Application no: **3/2023/0410**

Address: **Cunliffe House Farm Longsight Road Langho BB6 8AD**

Proposal: **New single storey detached building to be used as a fire/stove showroom along with parking spaces.**

The Local Highway Authority have viewed the plans and highway related documents and have the following comments to make:

Proposed Site Plan 1:200

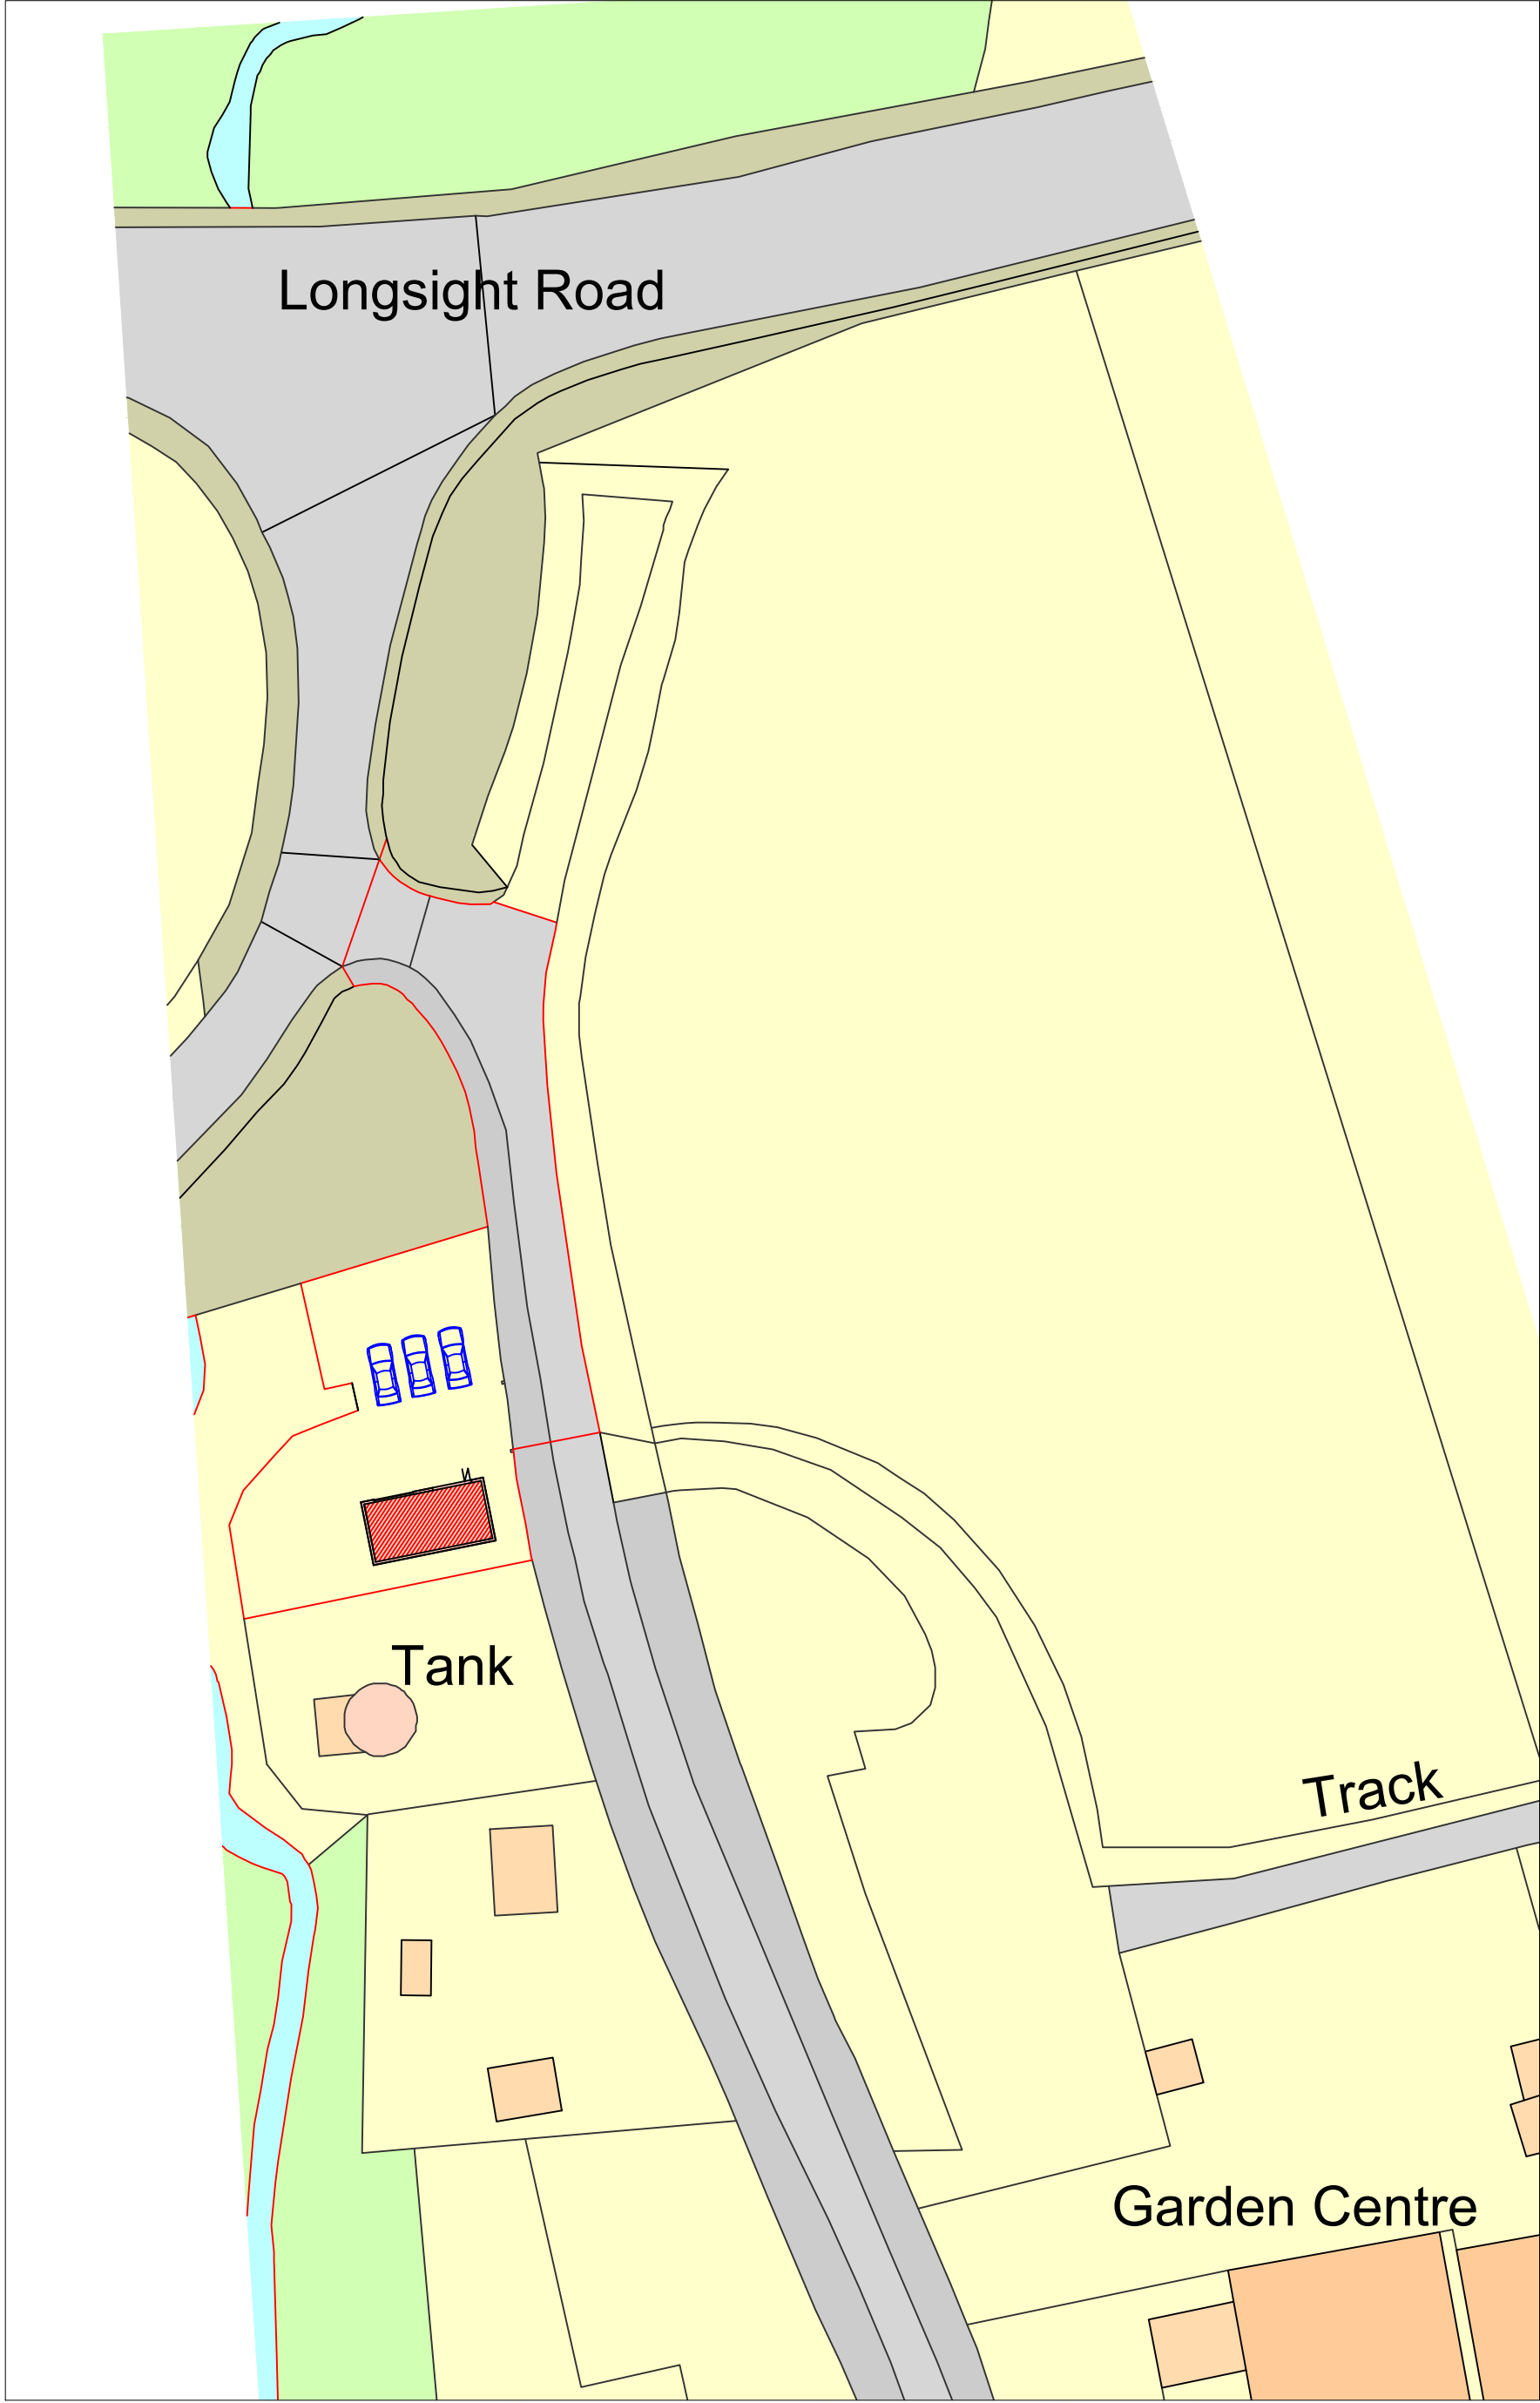
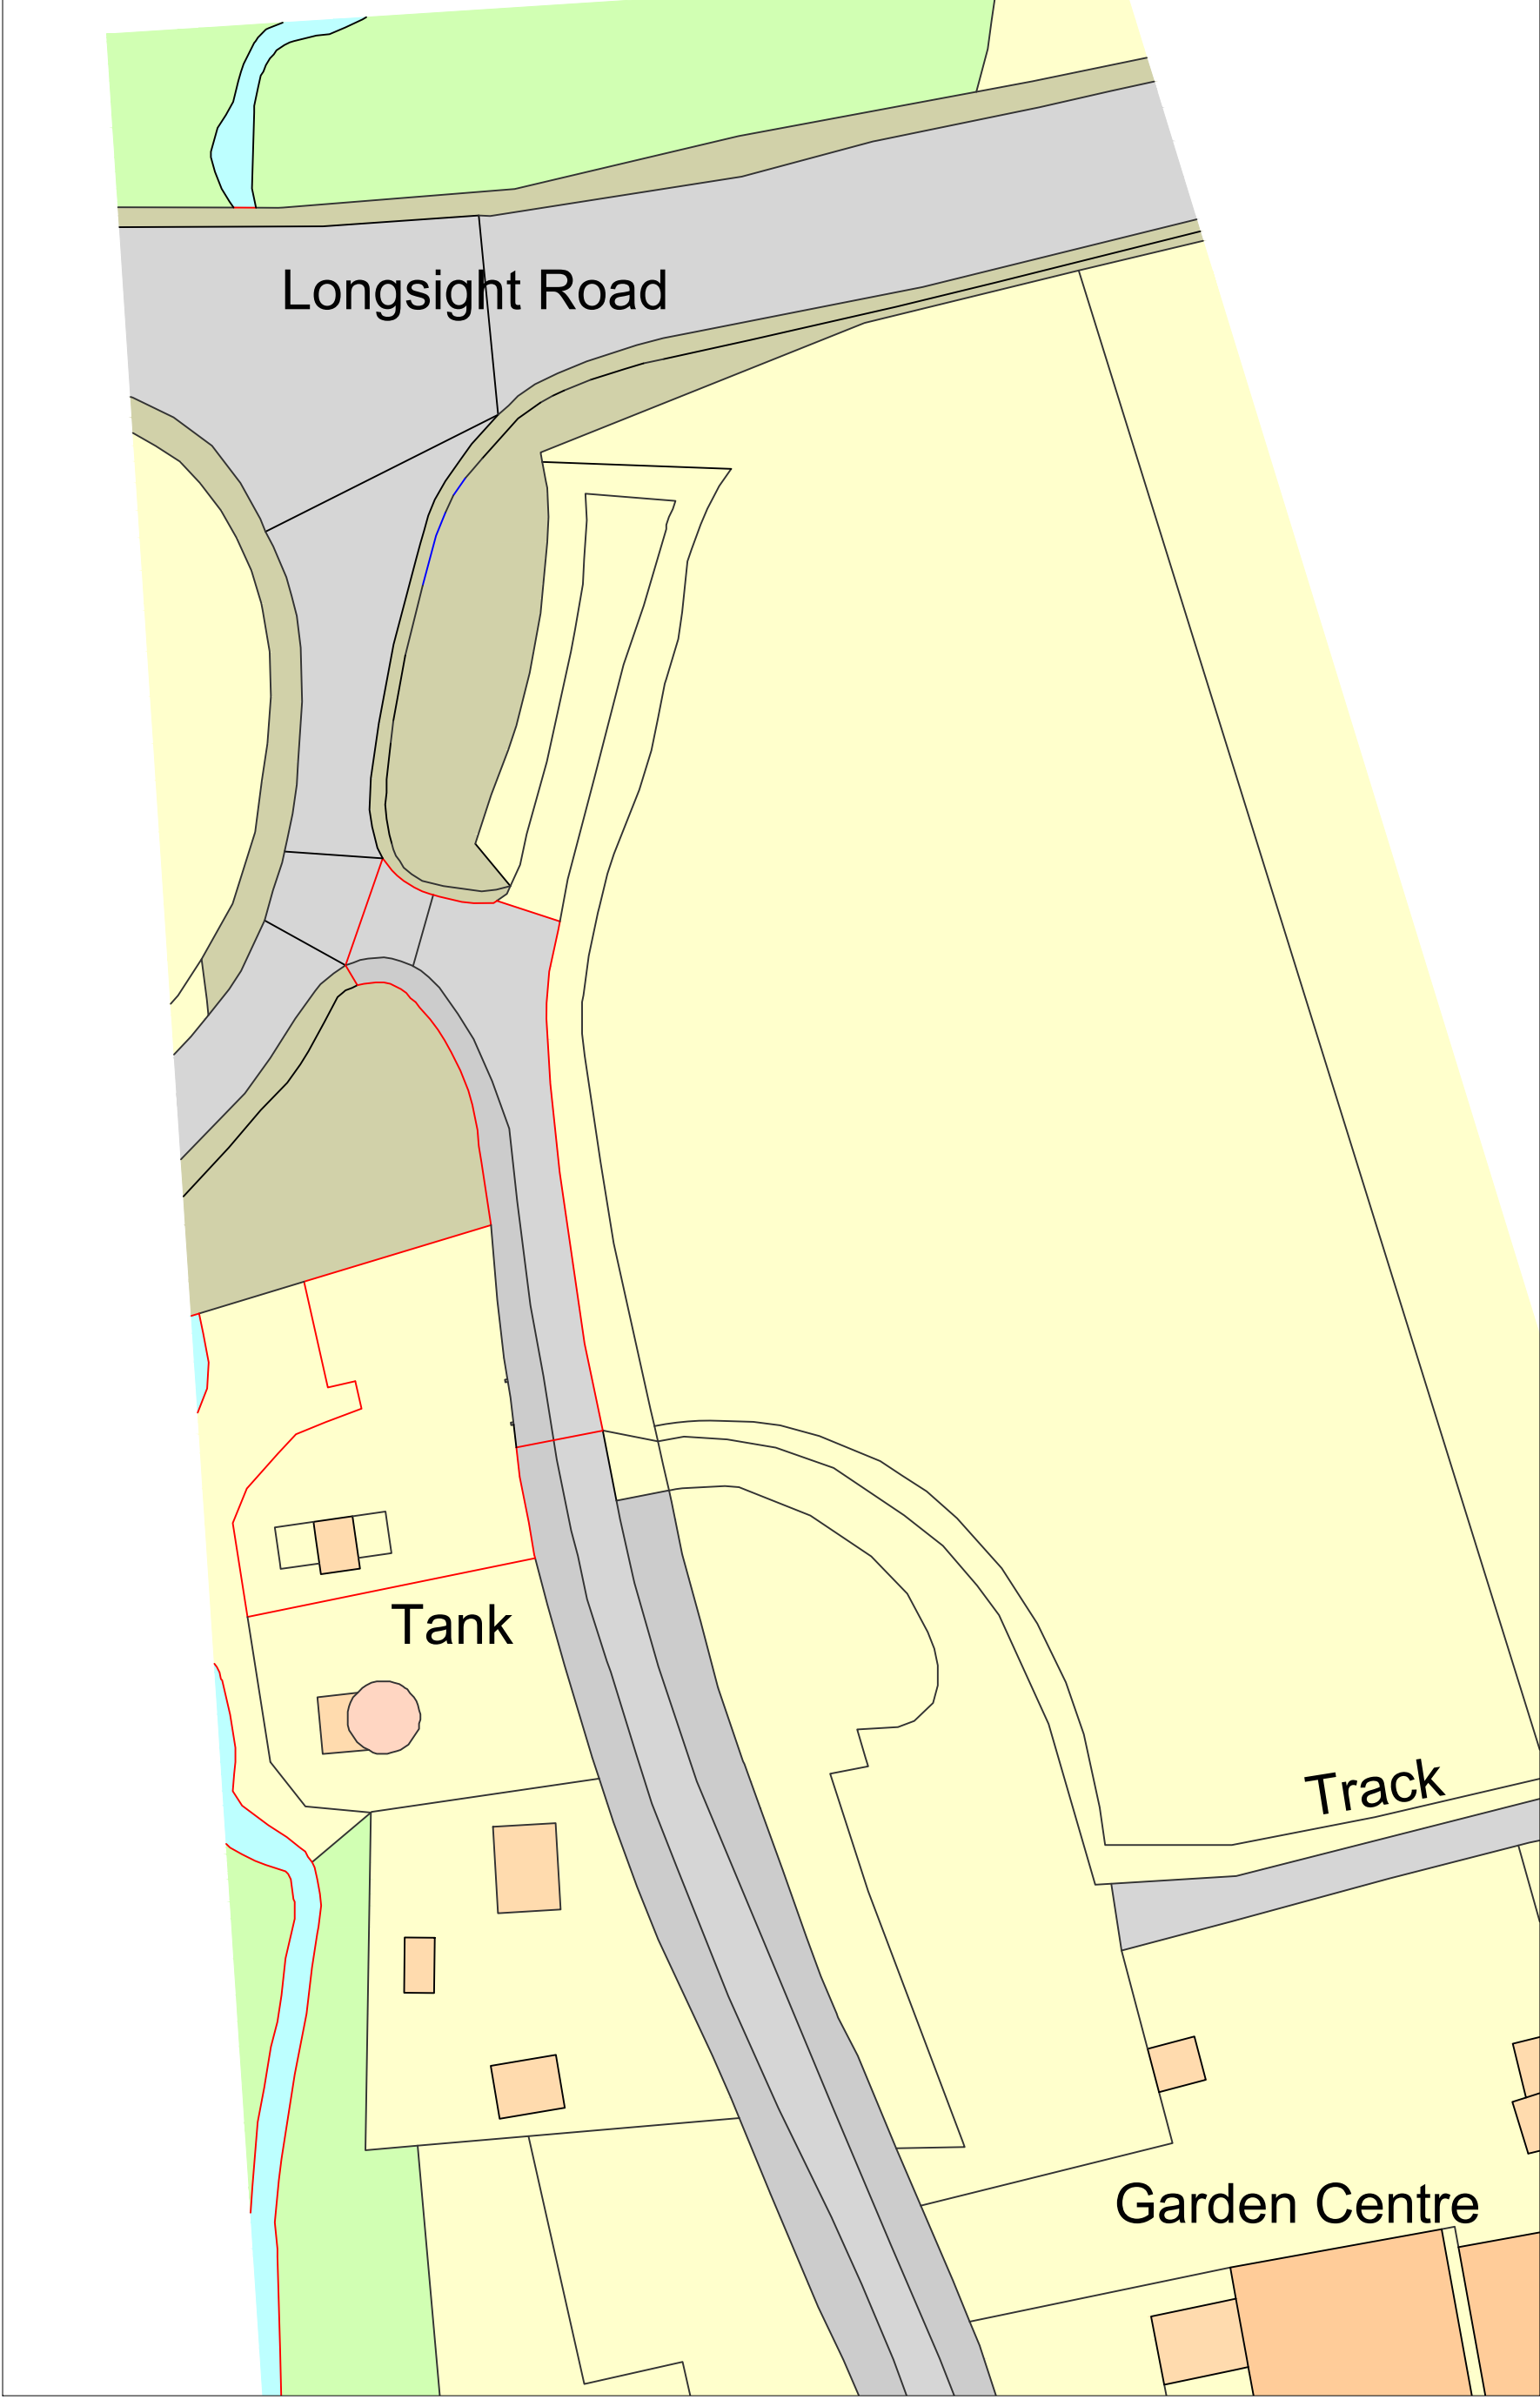
The LHA have reviewed Entwistle Design drawing number 2 of 2 Site Plan and are aware that 3 car parking spaces will be provided. Before the LHA can assess whether the quantity of parking is suitable for the development, the LHA require details regarding the maximum number of staff members who will be on site at any one time.

The LHA also require further information in the guise of an internal site access plan. The LHA require an internal site access plan showing the access to the proposed showroom. Currently no information has been submitted regarding the access width and so to ensure that the access is safe and suitable for the public, the LHA request a plan is submitted.
